**City of Portland, Maine - Building or Use Permit**

Permit No: 08-1220	Date Applied For: 09/29/2008	CBL: 034A B001001
-----------------------	---------------------------------	----------------------

Proposed Use: Commercial - "Perx-U-Up Cafe" Description 3 Banner signs 3' x 14'	Proposed Project Description: 3 Banner signs 3' x 14'
---	--

Dept: Zoning	Status:	Reviewer: Ann Machado	Approval Date:	Ok to Issue: <input type="checkbox"/>
Note: Not meet sign regulations for B-7 zone. Gave permit to Rick Knowland for review under section 14-368.5(g)				
Dept: Building	Status: Pending	Reviewer:	Approval Date:	Ok to Issue: <input type="checkbox"/>
Note:				
Dept: Planning	Status: Pending	Reviewer: Rick Knowland	Approval Date:	Ok to Issue: <input type="checkbox"/>
Note:

**RID2** MARGINAL WAY ELEVATION—PHASE 1 RETAIL TENANT ID—BANNERS  
**A** SCALE: 1/16"=1'-0"

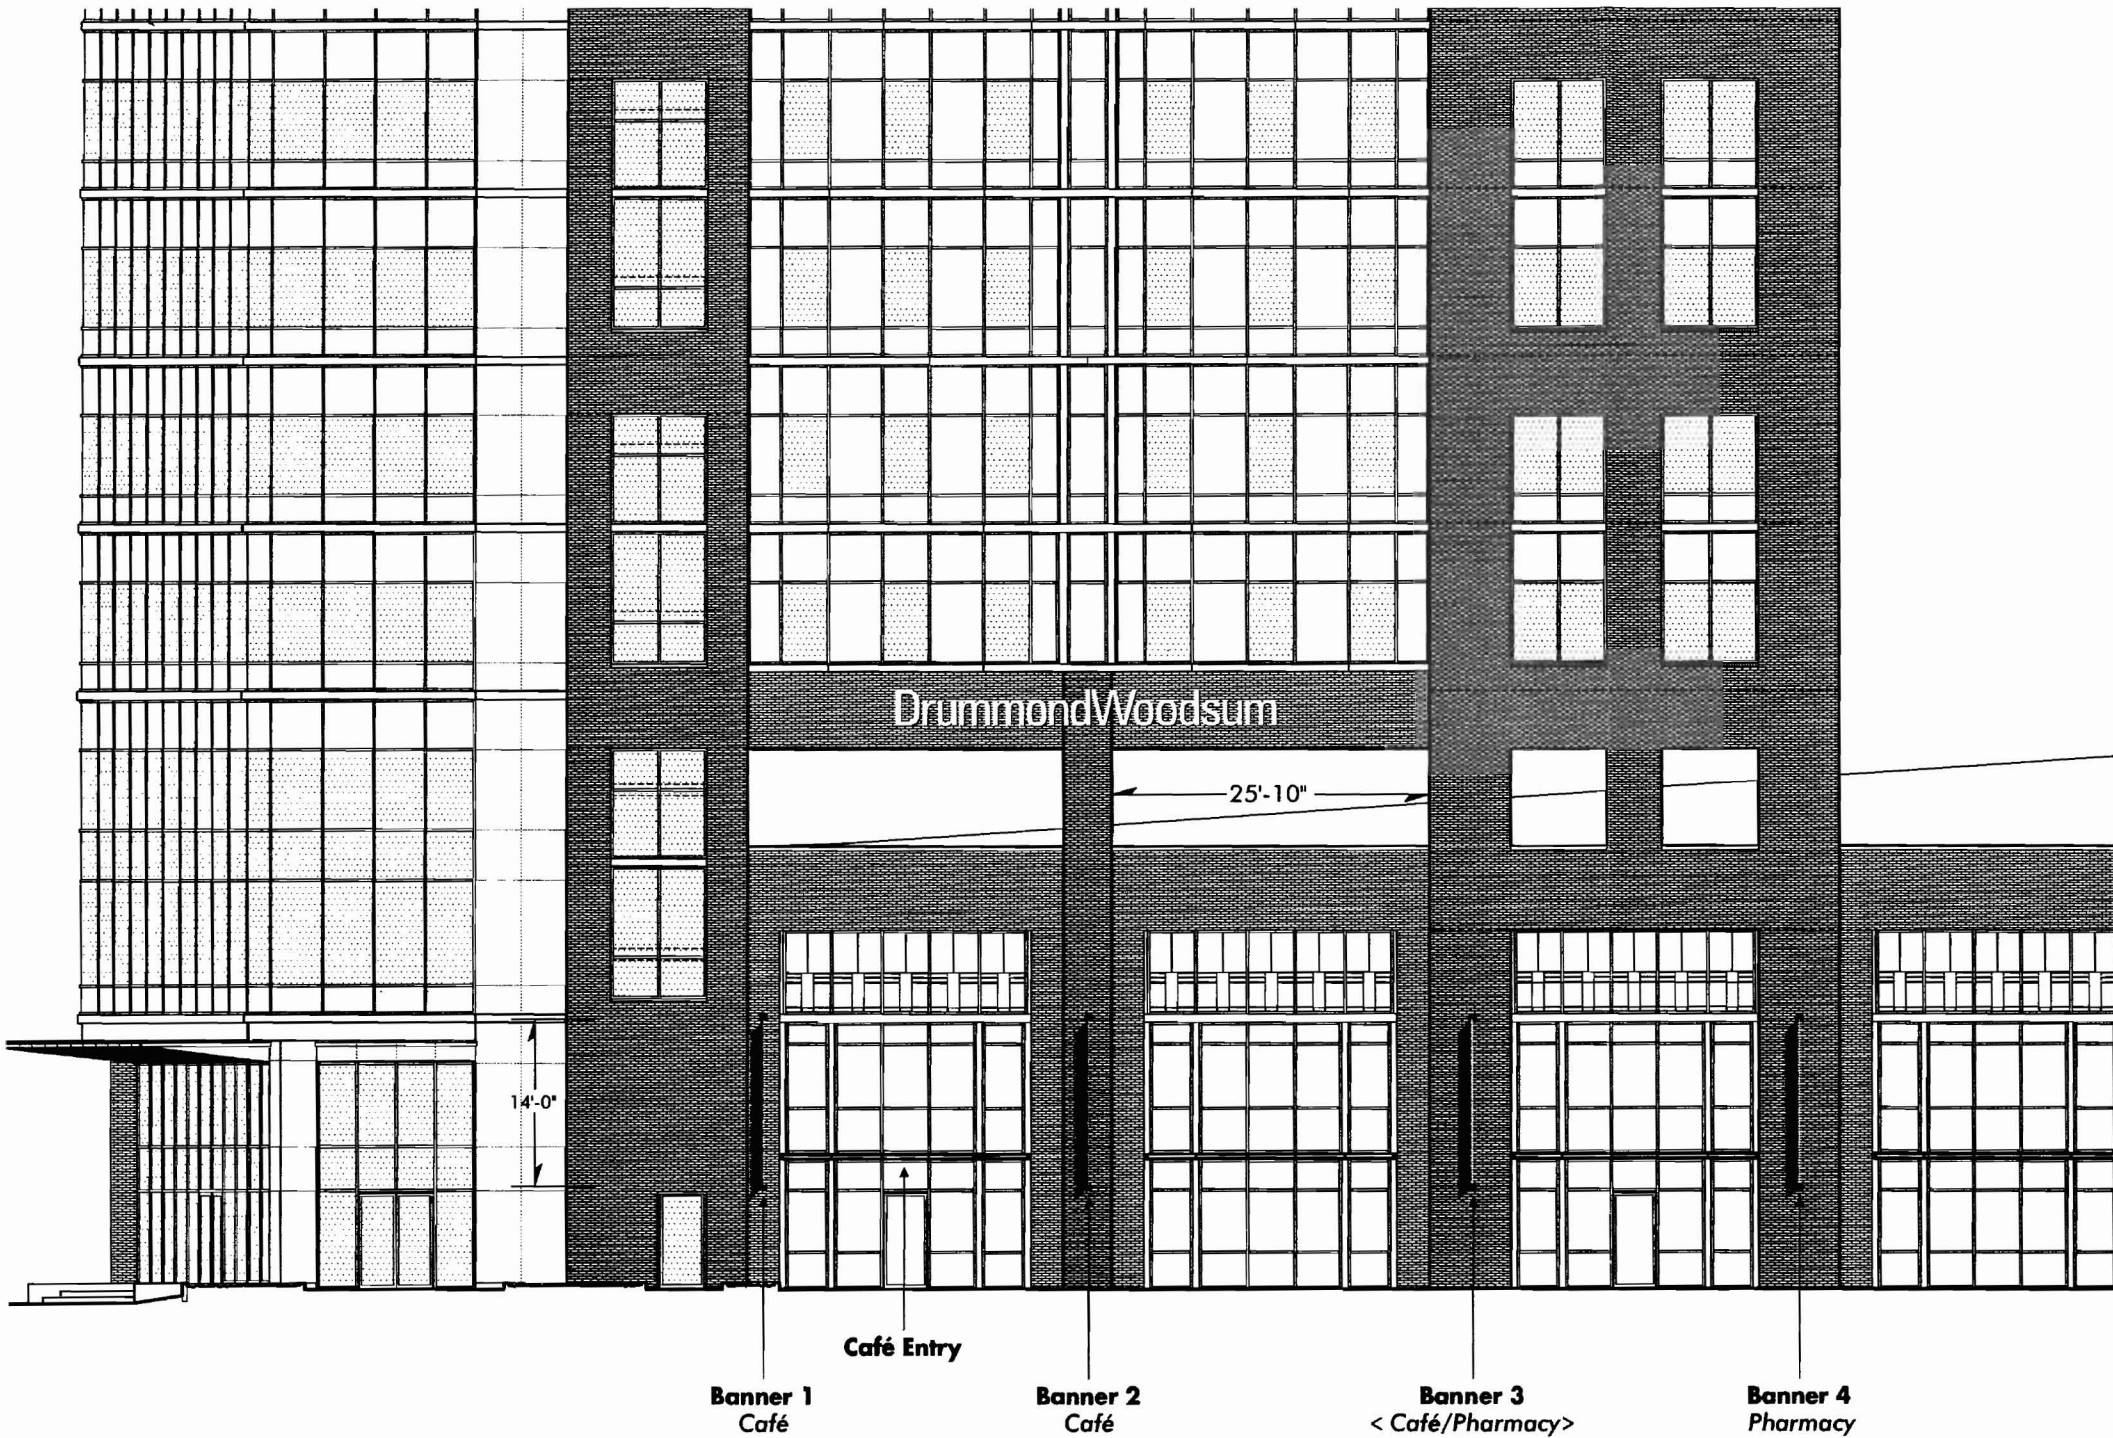
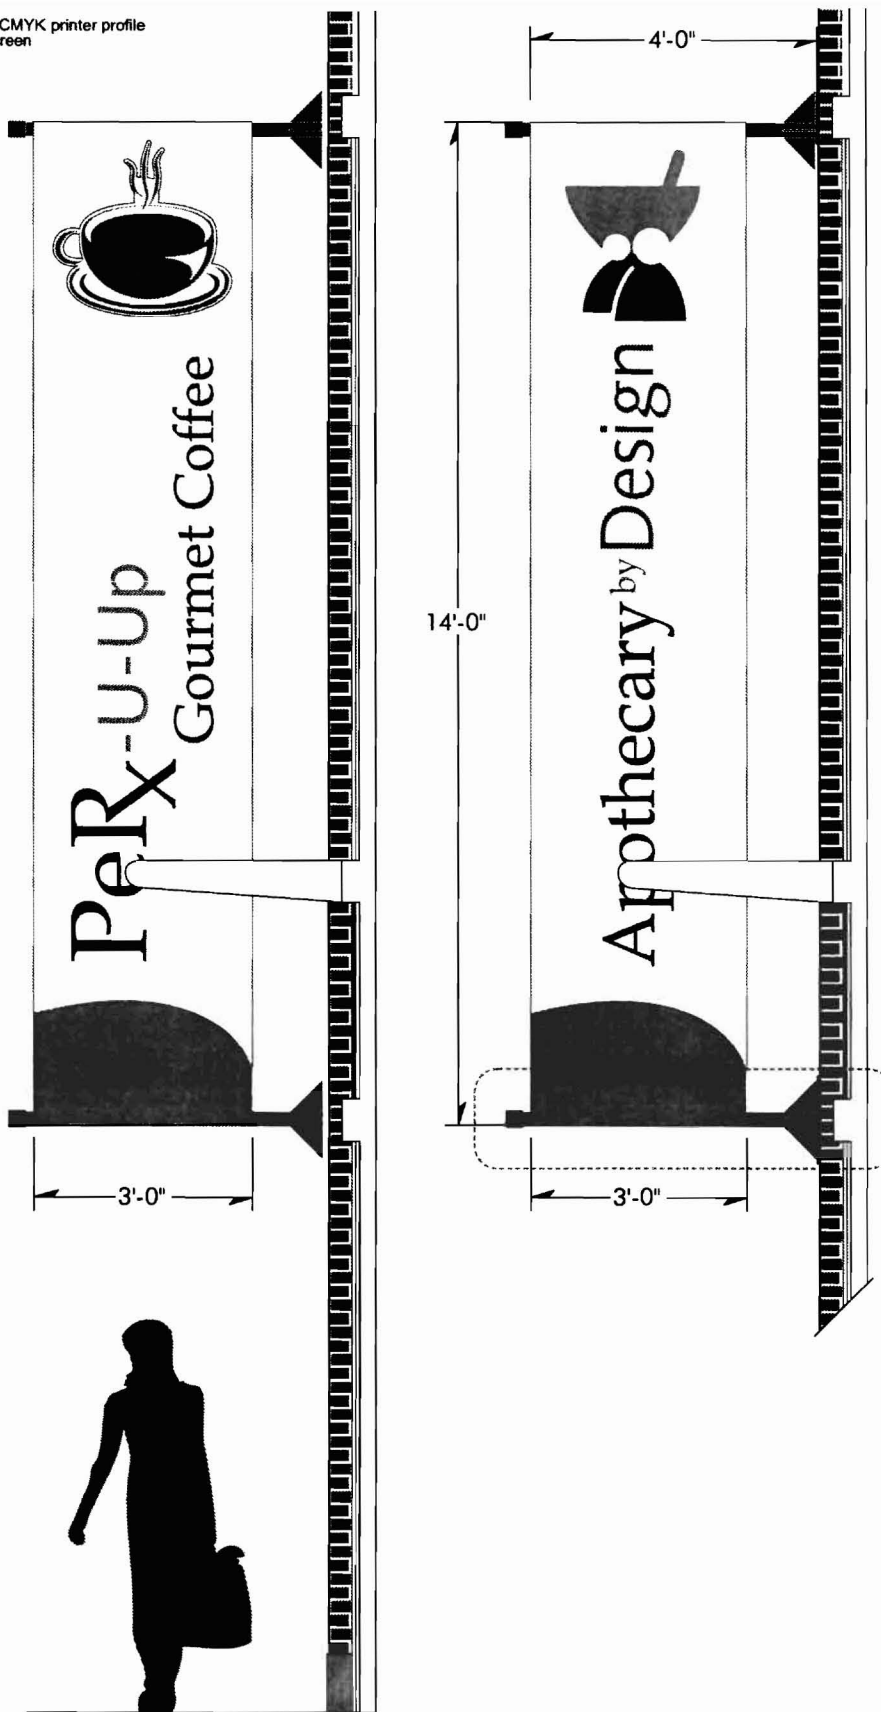
10/1/2008-amachado: Application does not meet sign regulations for B-7 zone. Individual ground floor tenants are only allowed one sign per tenant. This application is for three banner signs. Gave to Rick Knowland in planning under section 14-368.5(g).

11/4/2008-amachado: Spoke to Rick. The applicant has decided not to pursue the banners.
